**Consultation Response from KC,
Trees**

2026/90702 Fieldhead, Snelsins Road, Cleckheaton, BD19 3UE

Demolition of existing outbuildings and erection of detached leisure building, car port and annex accommodation associated with Fieldhead, Snelsins Road, Cleckheaton, BD19 3UE

Date Responded: 23/06/2026

PROPOSED SITE PLAN

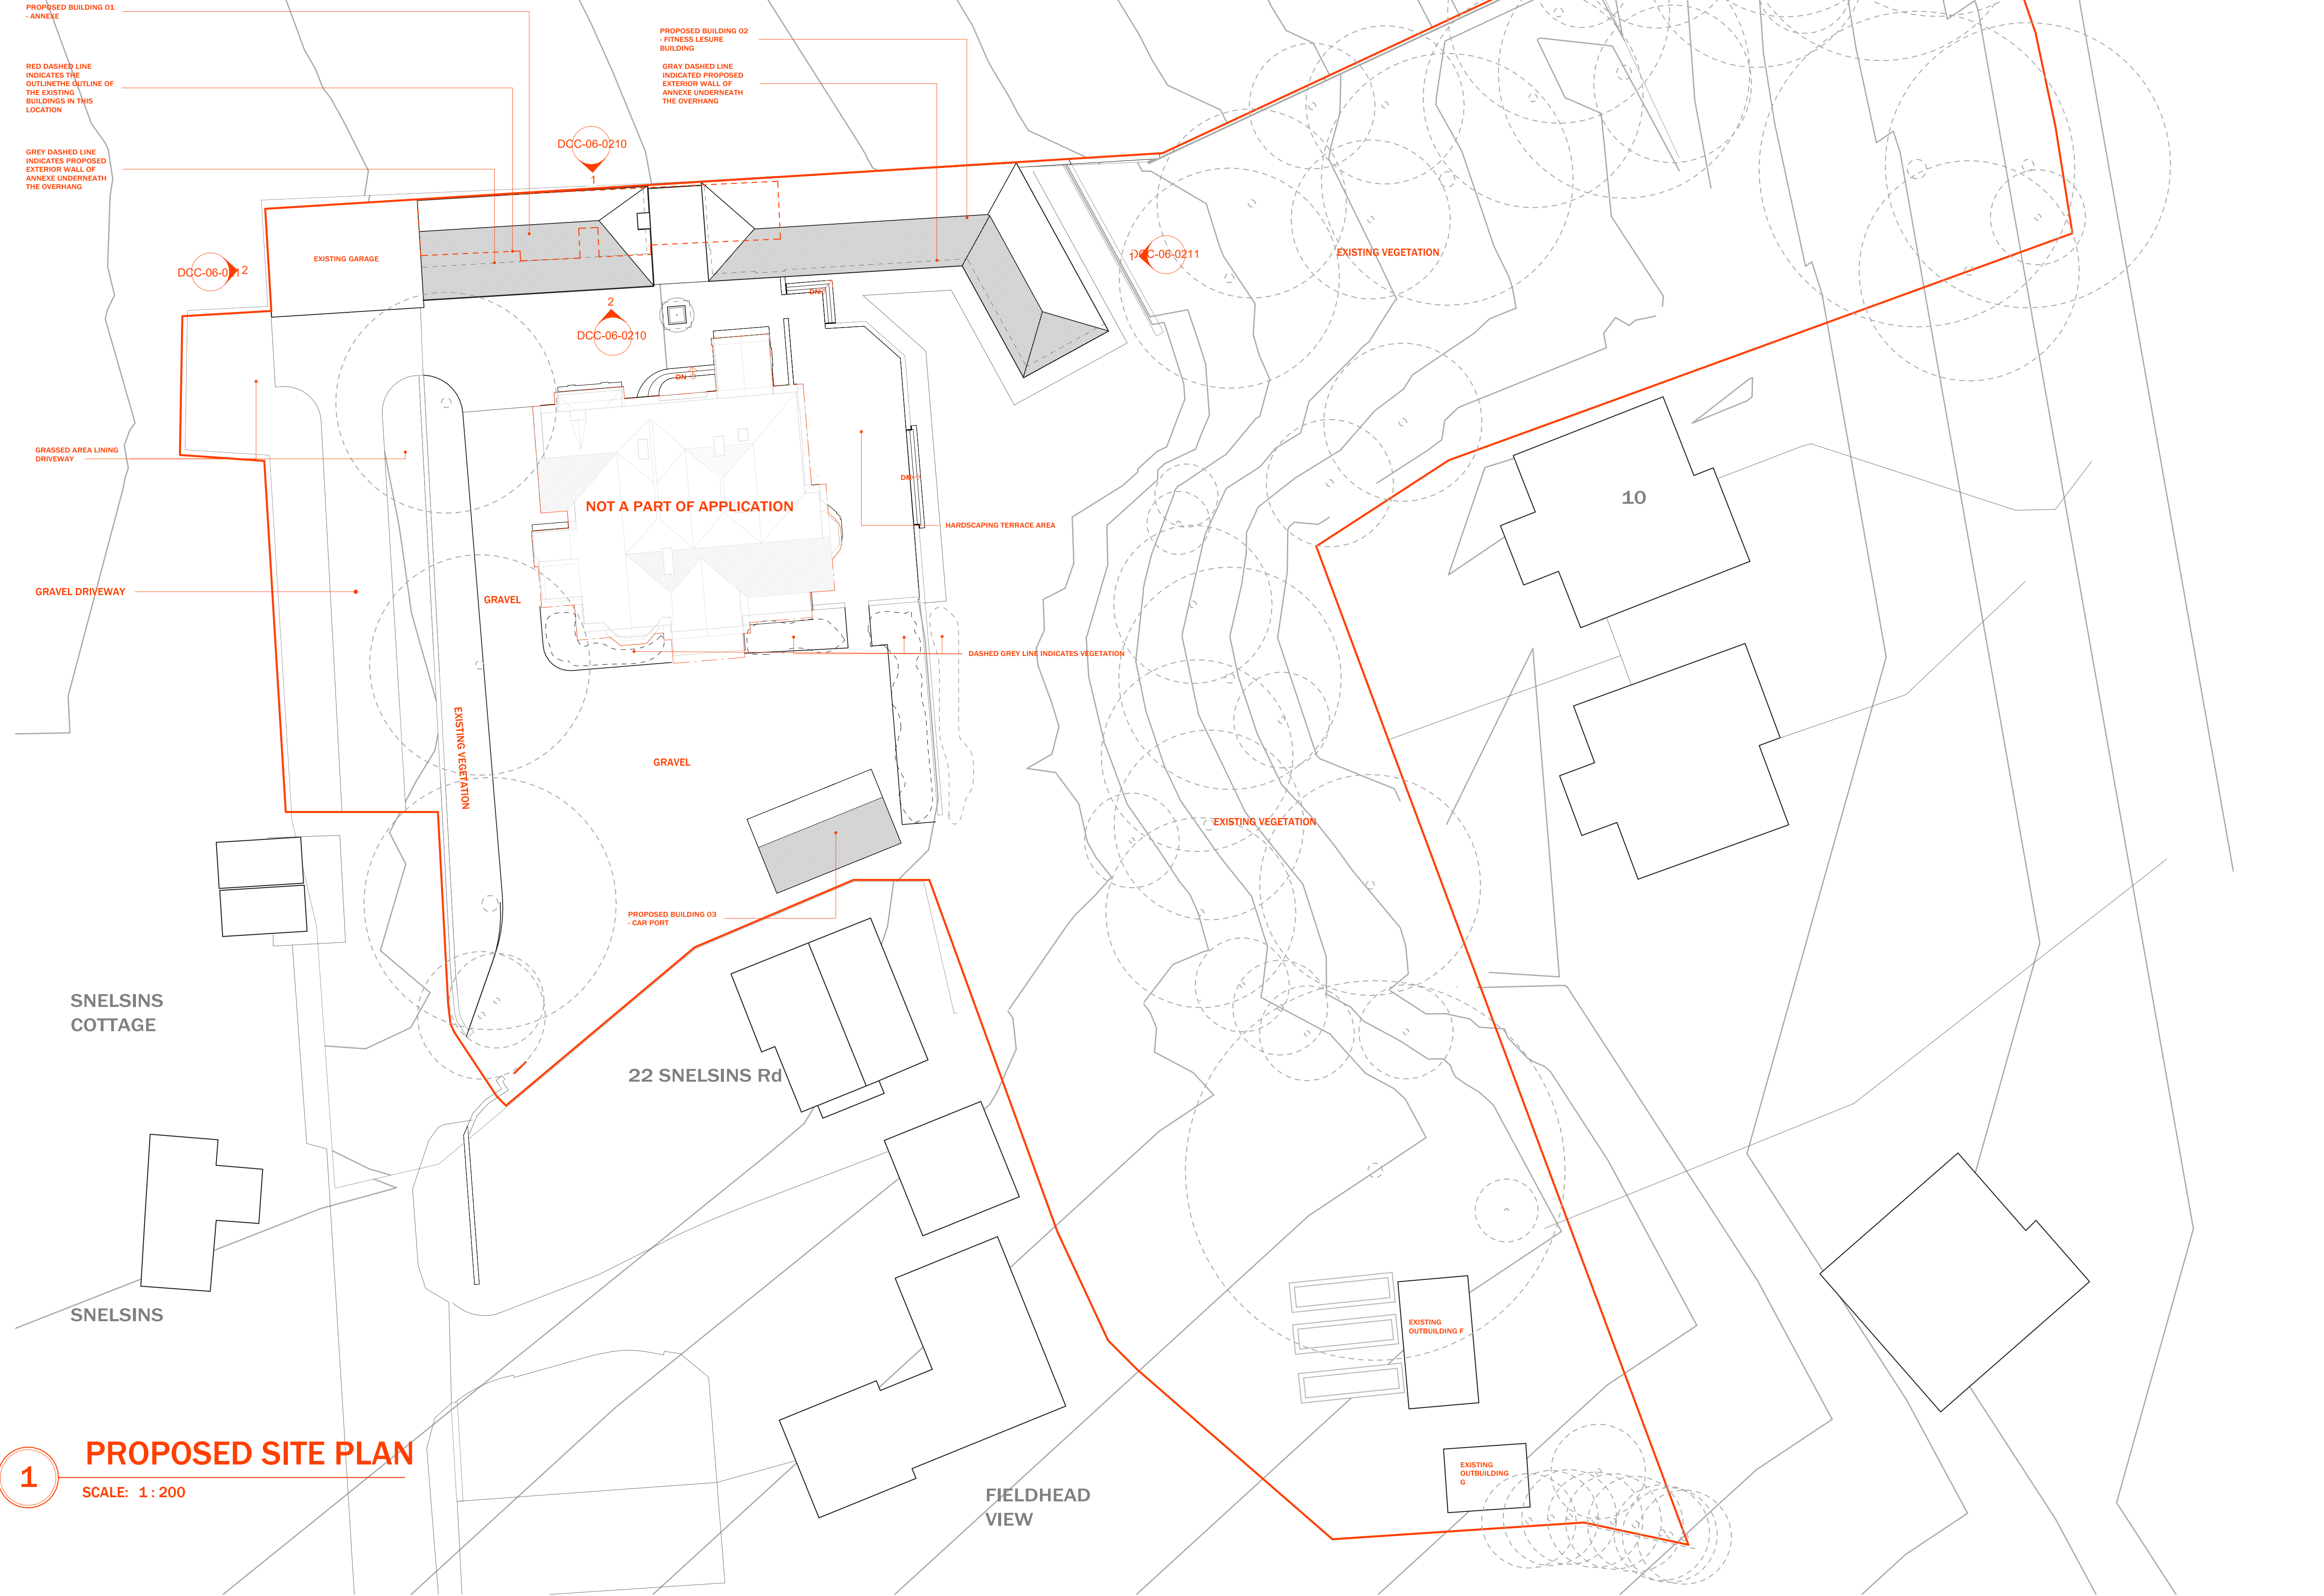
There are trees within the site which could potentially be impacted by the development of these proposals. This includes trees protected by SP2/70.

The proposals cannot be accepted from an arboricultural perspective as they threaten T11, a protected tree. **All development must be sited outside of canopies and root protection areas, as previously discussed.**

There is an objection from an arboricultural perspective. The proposal conflicts with adopted Kirklees local plan policy 33 and 24 (i). Please see below:
